OUT12/10797  
FILE 12/2130#2

**Re: North West Rail Link – Notice of Exhibition  
Staged SSI Modification (MP\_06/0157)  
SSI Application – Major Civil Construction Works (SSI-5100)**

Thank you for your letter of 3 April 2012 relating to the above projects. This is a response from Trade & Investment – Mineral Resources Branch. Please note Trade & Investment – Primary Industries Division (DPI) will provide advice in separate correspondence. The Mineral Resources Branch has assessed the documentation and offers the following advice.

Figure 6.5 Approved and Modified Alignments - Kellyville Station to Tallawong Stabling

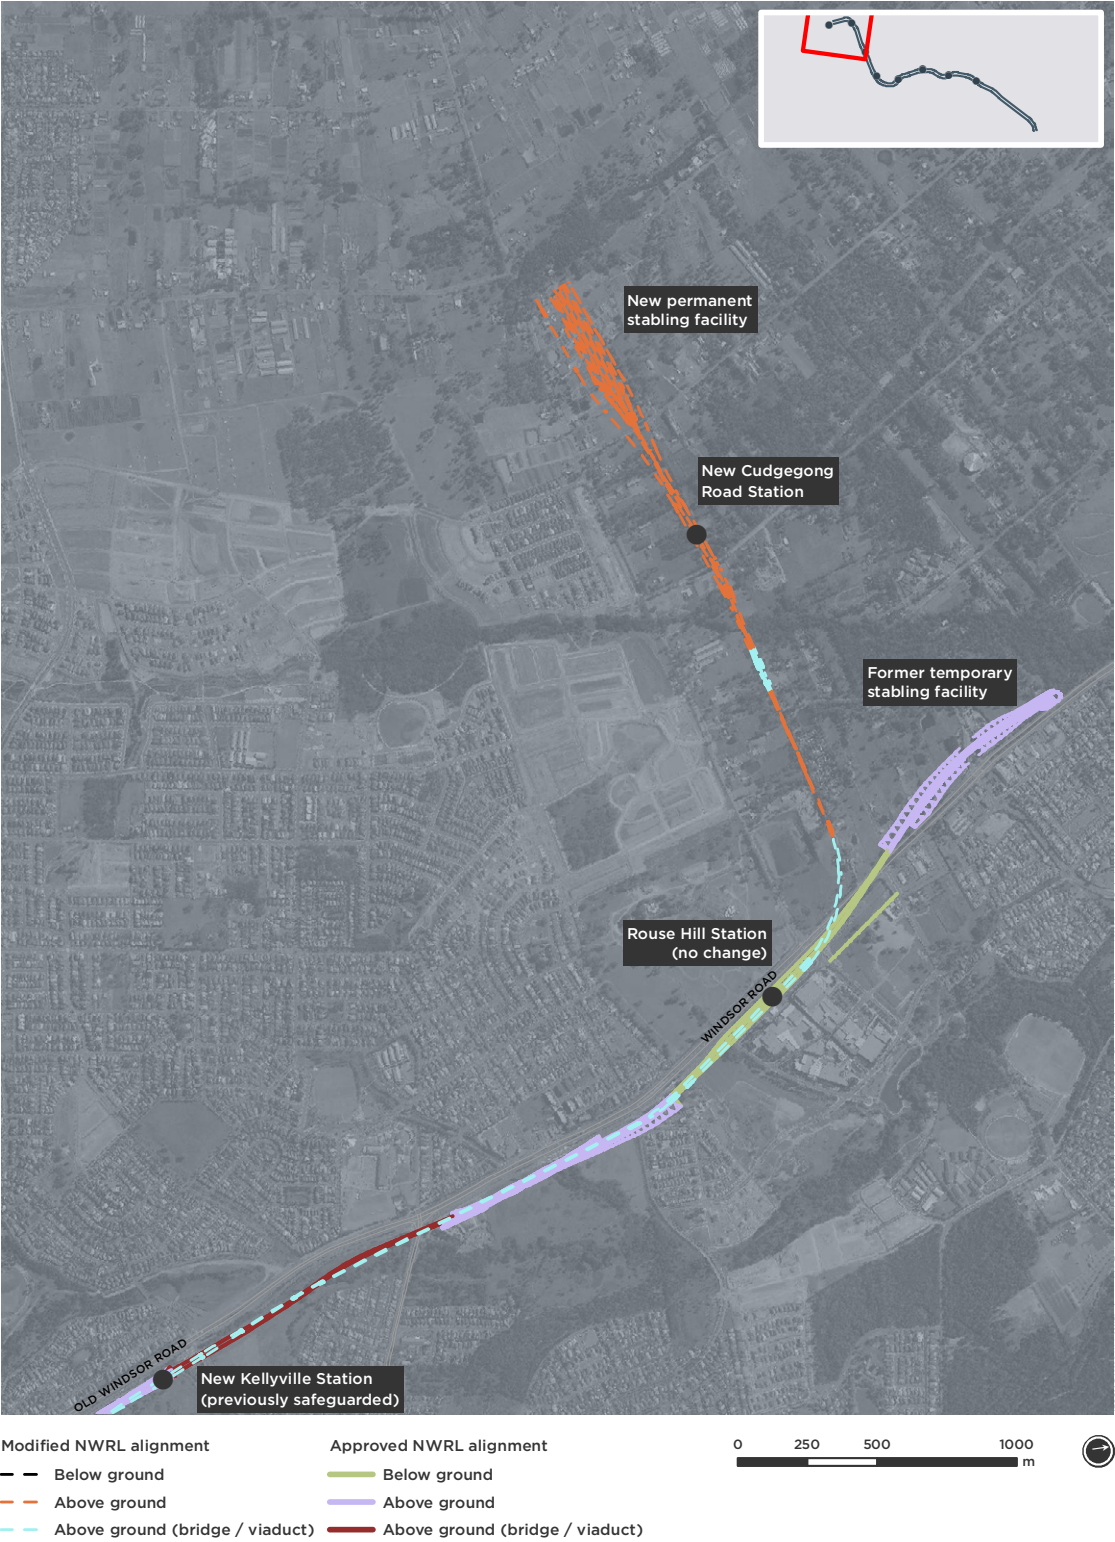
It is unclear from the EIS how the Rouse Hill Shale Quarry operated by Blacktown City Council will be affected by the project. It appears that the alignment directly intersects the shale quarry (refer to Figure 1 below). It is not clear whether consultation has been undertaken with Blacktown City Council on the matter of resource sterilisation at this site.
